Application number: 2020/90784	
What is the application for?:	Alterations to convert part of existing newsagent into prayer facility
Address of the site or building:	260-262, Wakefield Road, Earlsheaton, Dewsbury, WF12 8AN
Postcode:	WF12 8AN

Figure 1. Proposed internal arrangement of the prayer facility

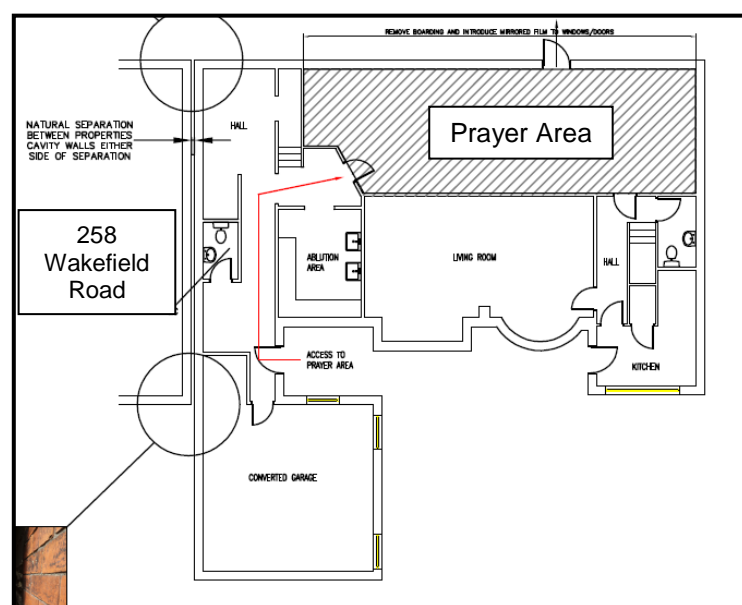
Type of comment: An objection
Parking will be a huge problem, 3 schools all in the local vicinity which finish at same time as afternoon prayers, there is no far more suitable places and not a need in this area of the community for a mosque, there is at least 5 or 6 that I know of within in 2 miles which are far more equipped to cope with the disruptions this would cause to the surrounding streets and roads
